**WELWYN HATFIELD BOROUGH COUNCIL  
EXECUTIVE DIRECTOR - PLANNING, PUBLIC PROTECTION AND GOVERNANCE**

**DELEGATED APPLICATION**

**Application No:** 6/2018/0271/LAWP  
**Location:** 13 Theobalds Road Cuffley Potters Bar EN6 4HQ  
**Proposal:** Certificate of lawfulness for a hip to gable loft conversion and installation of rear dormer and 2 front roof lights  
**Officer:** Ms Lucy Hale

6/2018/0271/LAWP

Amendments:	
CARTER SURVEYING ASSOCIATES 07941 443968	
SITE ADDRESS:	CLIENT:
13 THEOBALDS ROAD CUFFLEY, HERTS. EN6 4HQ	MR K BURGESS
PROJECT:	DRAWING:
LOFT CONVERSION	PLANNING
SCALES: 1:50 1:100 @ A1	DATE: FEB 2018
DRAWING NO: BUR 01P	DRAWN: CSA
REVISION:	A

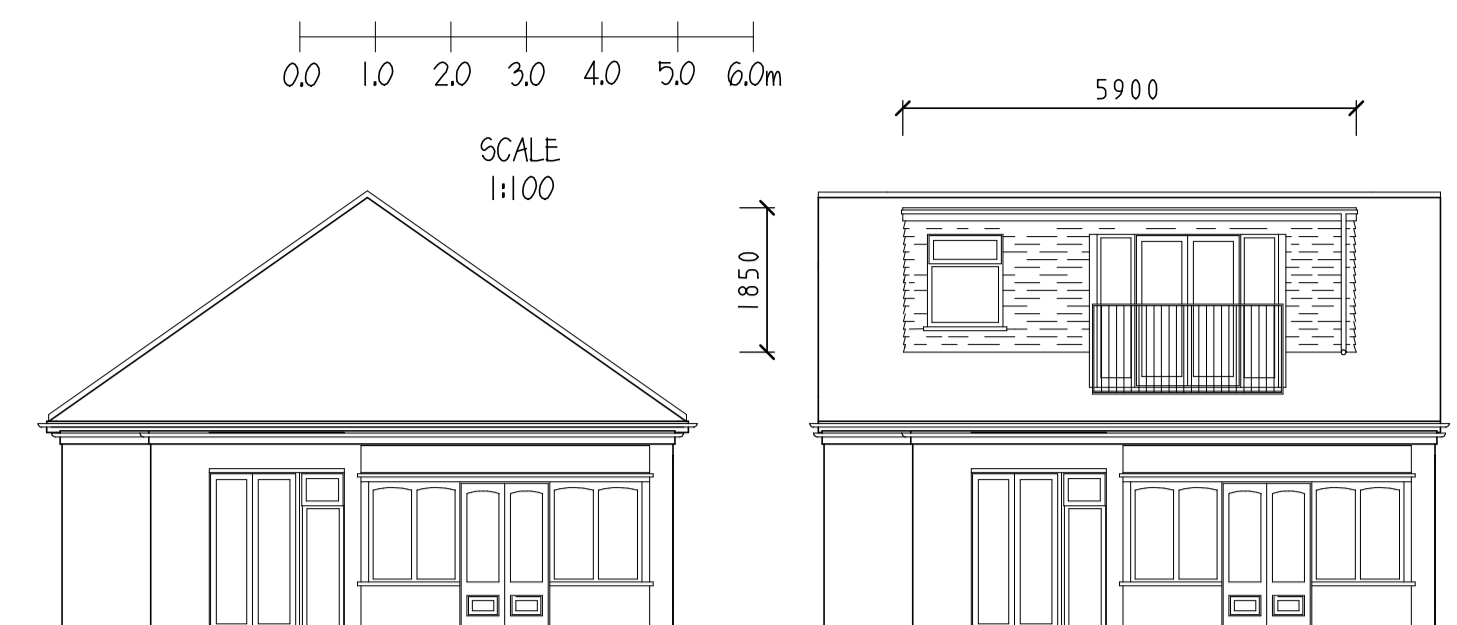
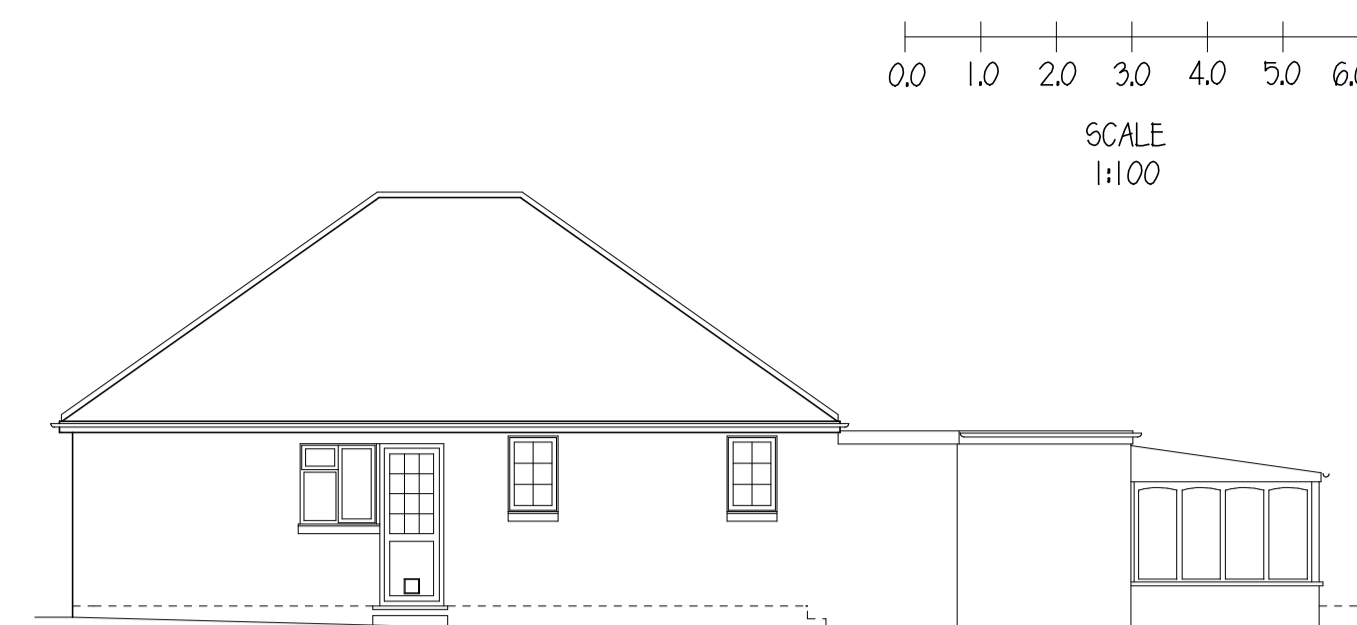
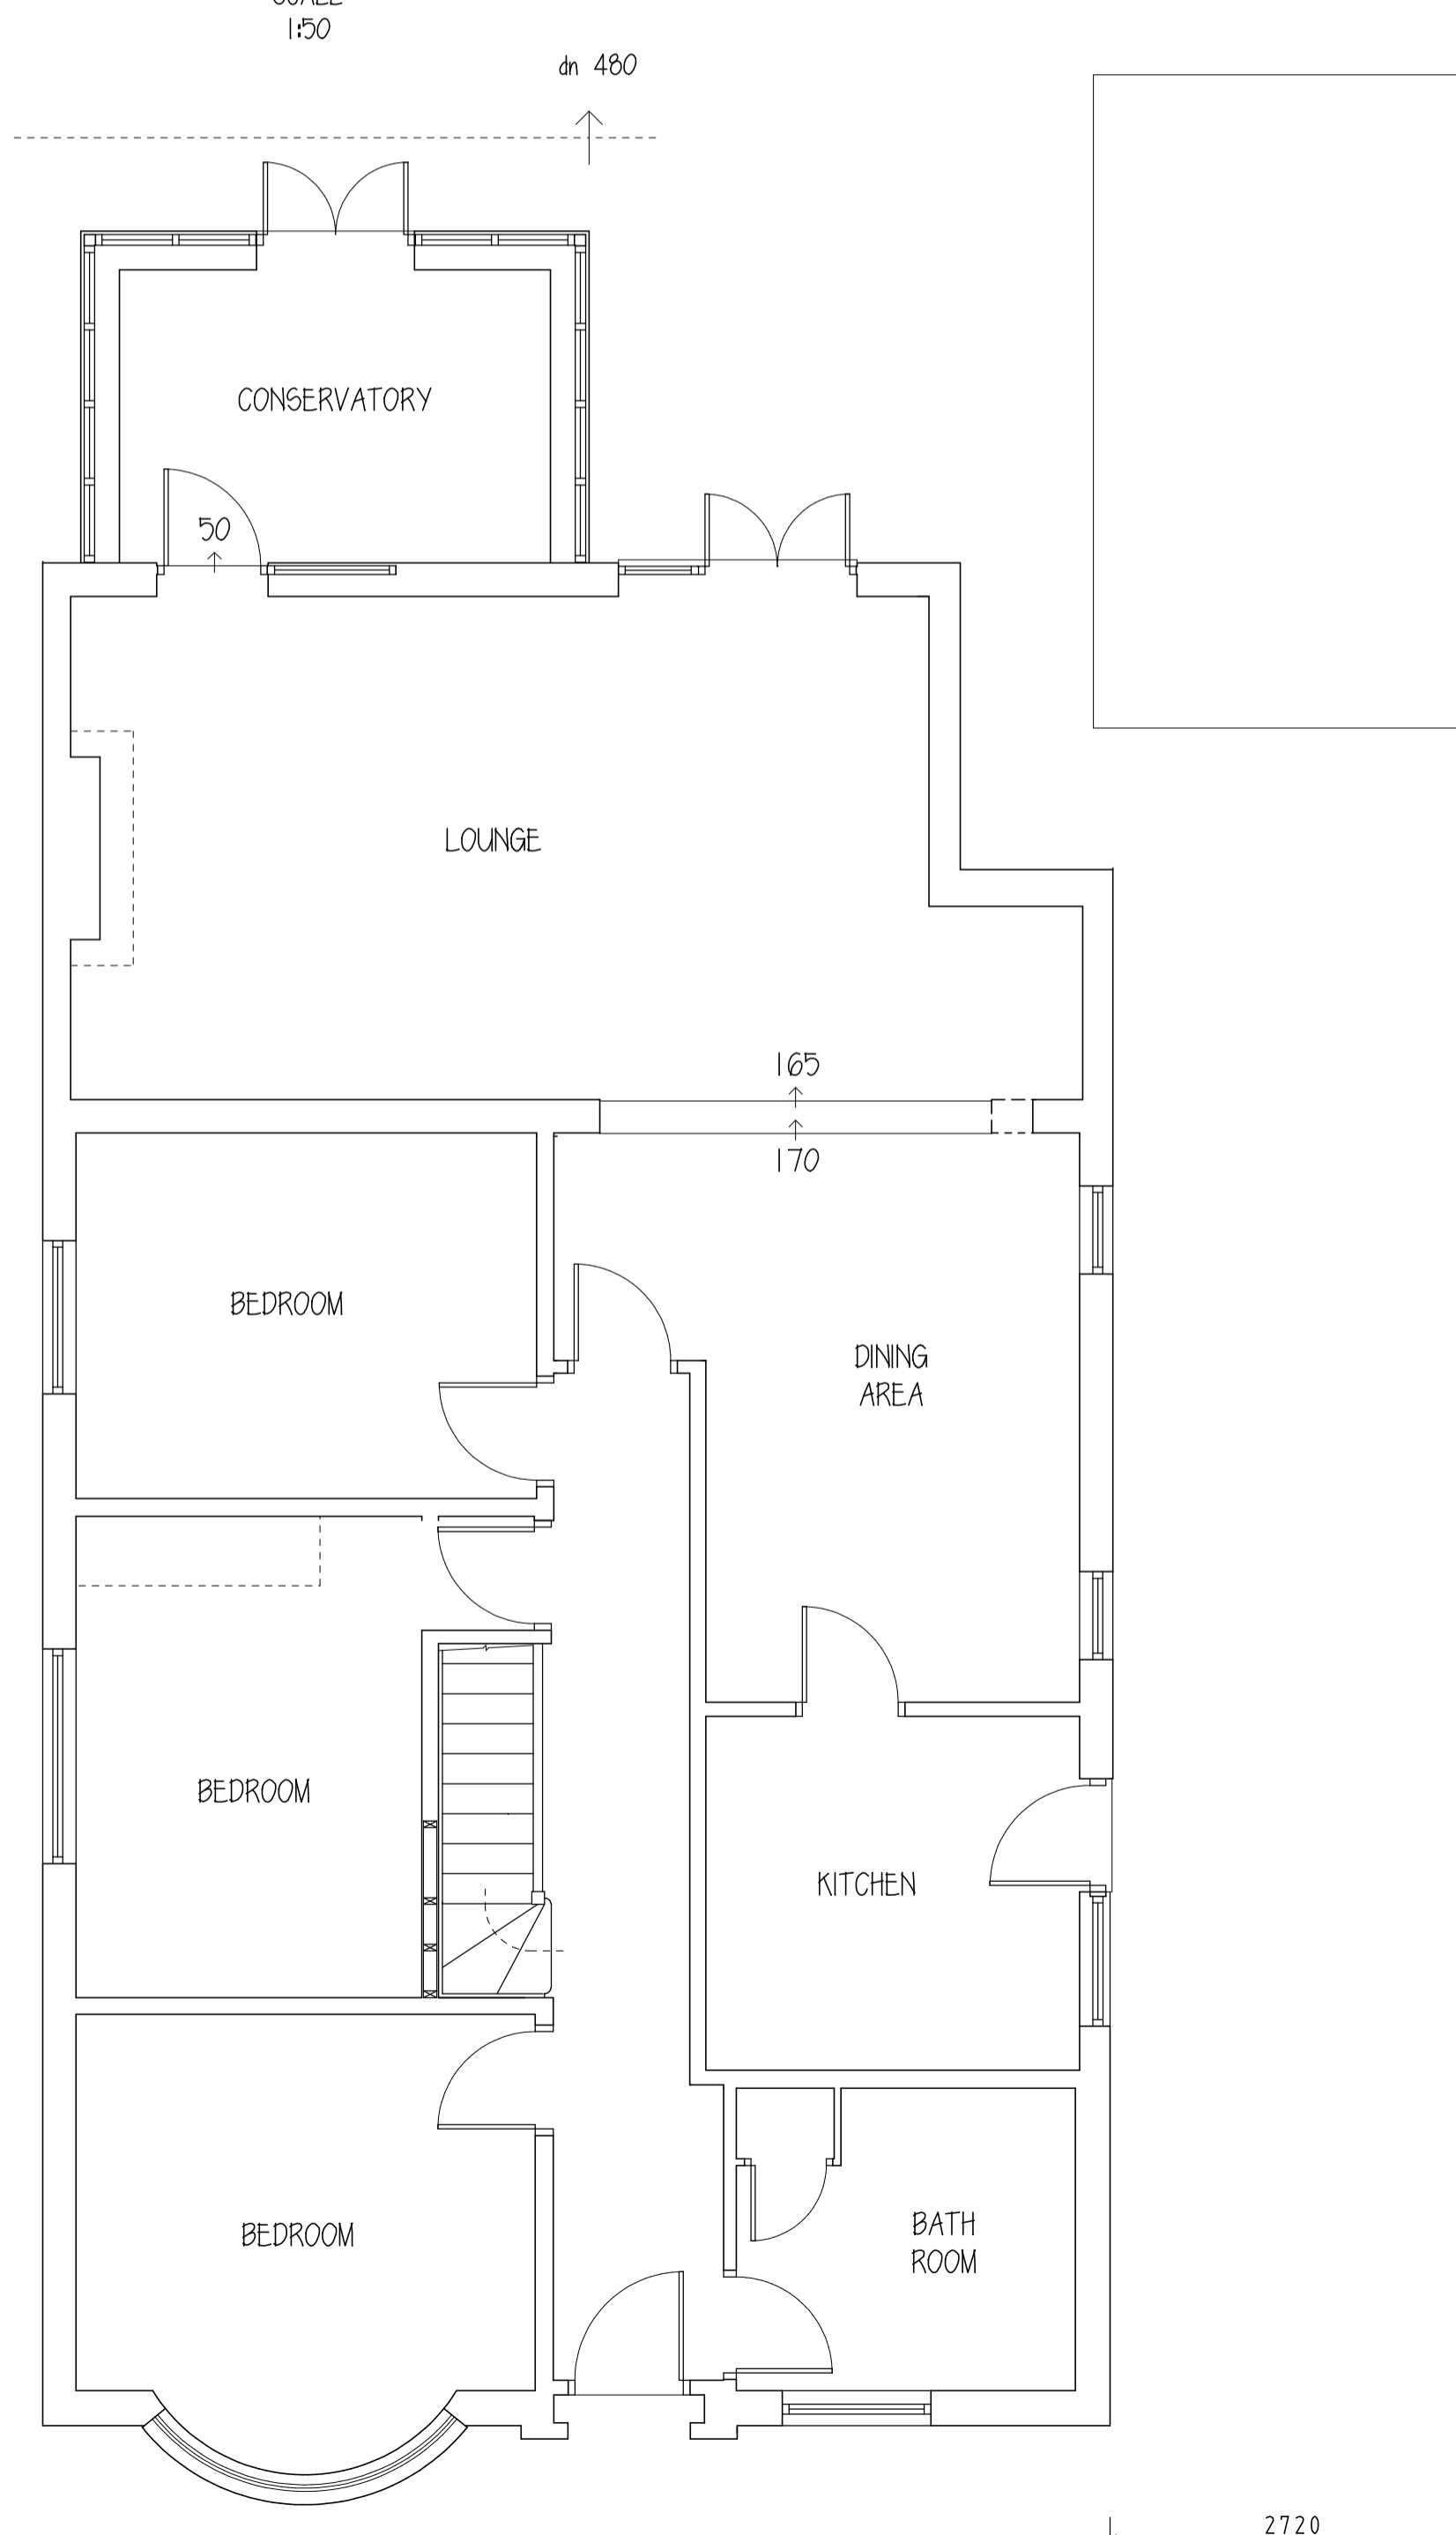
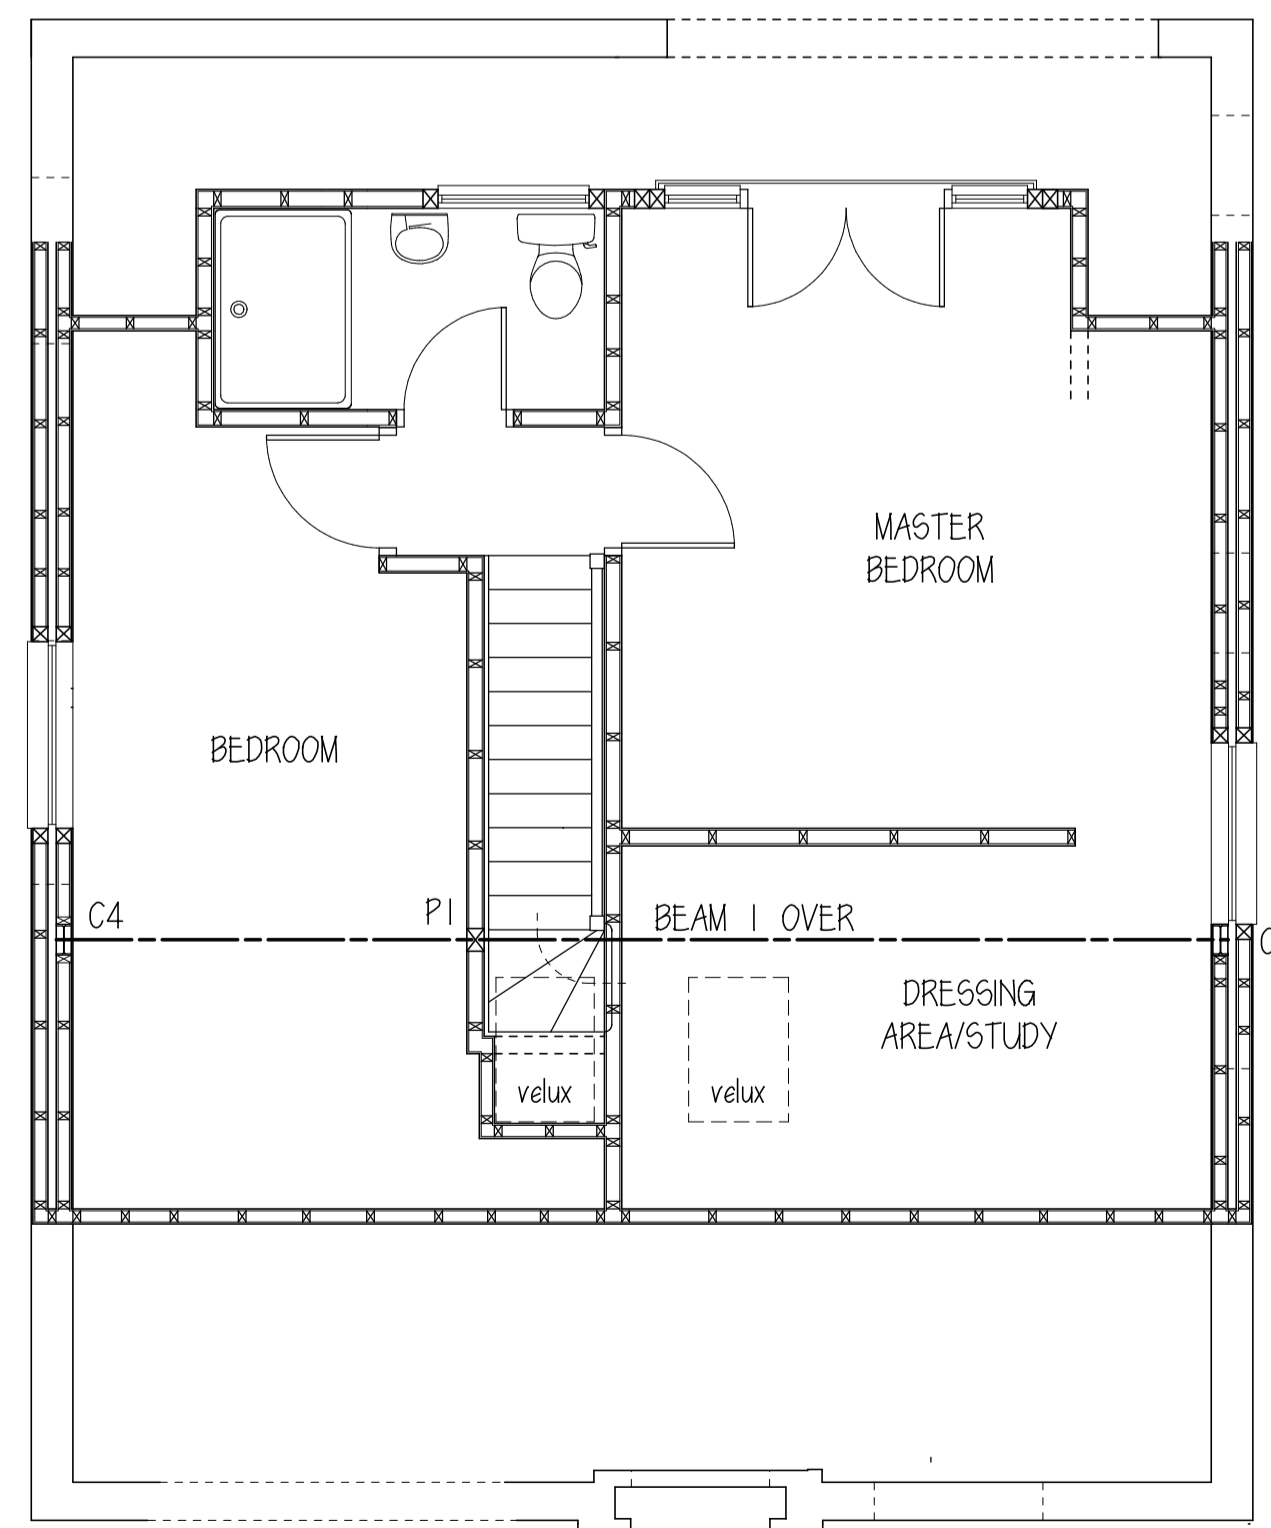
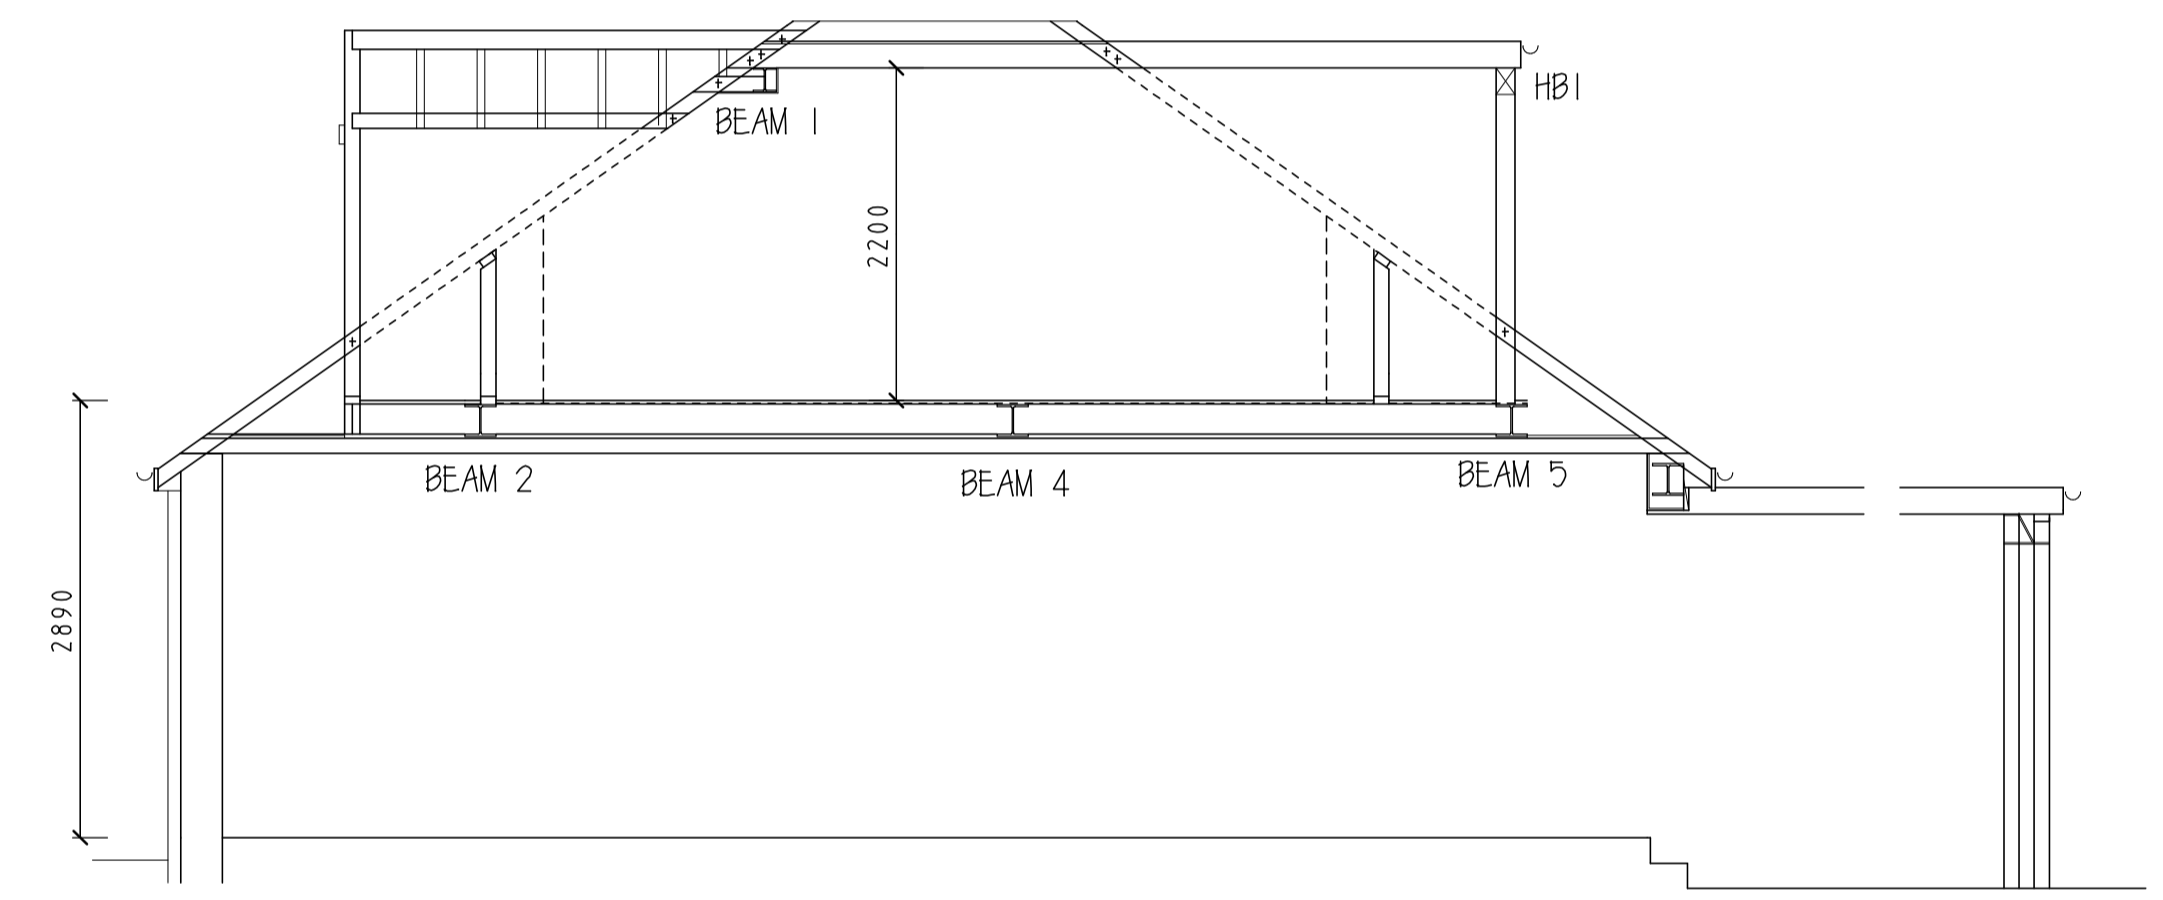
(d) would the cubic content of the resulting roof space exceed the cubic content of the original roof space by more than:- (i) 40 cubic metres in the case of a terrace house, or <b>(ii) 50 cubic metres in any other case</b>	<b>N</b>	N
<i>Hip to gable</i>

$2(9.85 (W) \times 3.95 (L) \times 2.75 (H)/6) = 35.67 \text{ cubic metres}$  <i>Dormer</i> $5.90 (L) \times 2.60 (D) \times 1.85(H)/2 = 14.19 \text{ cubic metres}$  <b>Total= 49.86 cubic metres</b>

(e) would it consist of or include:- (i) the construction or provision of a veranda, balcony or raised platform, or (ii) the installation, alteration or replacement of a chimney, flue or soil and vent pipe	<b>N – Juliet balcony</b>	N

2. The windows proposed on the roof slope forming a side elevation of the dwellinghouse must be obscure-glazed; and non-opening unless the parts of the window which can be opened are more than 1.7 metres above the floor of the room in which the window is installed.
